From: Martyn White <[REDACTED]>
Sent: 08 June 2020 15:52
To: Planning.Responses <Planning.Responses@arun.gov.uk>
Cc: Simon Davis <[REDACTED]>
Subject: Y/39/20/RES

Y/39/20/RES

Approval of reserved matters following outline consent Y/49/17/OUT & Section 73 permission Y/13/19/PL for 45 No. dwellings & associated works. This application may affect the setting of a Listed Building.

THE PROPOSALS

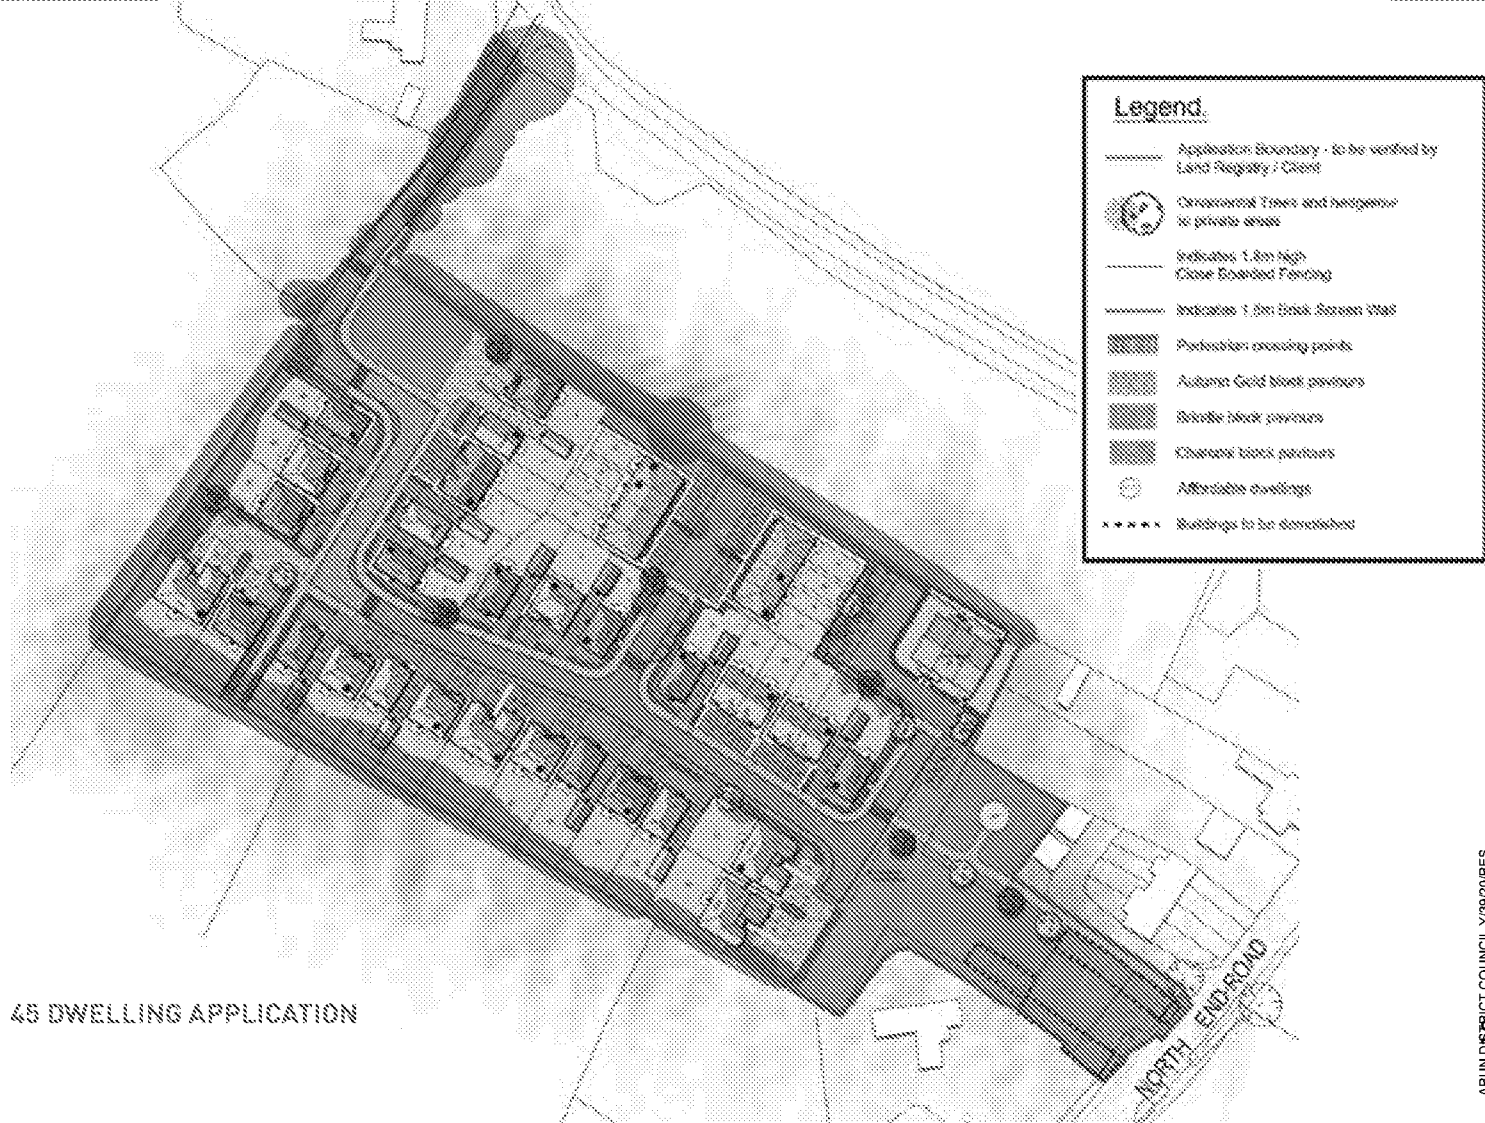
The design of the houses appear to be based on the designs of properties constructed in the early to mid C20, which are somewhat suitable for the character of the wider village, which grew substantially during the C.20. However, it is not clear why a large building (the Bromsgrove) has been located at the end of the curtilage of the listed building, when there is the opportunity to ensure that there is an attractive landscape buffer between the heritage assets and the new development.

The location of the building is potentially harmful, but it could be reduced through greater landscape buffering.
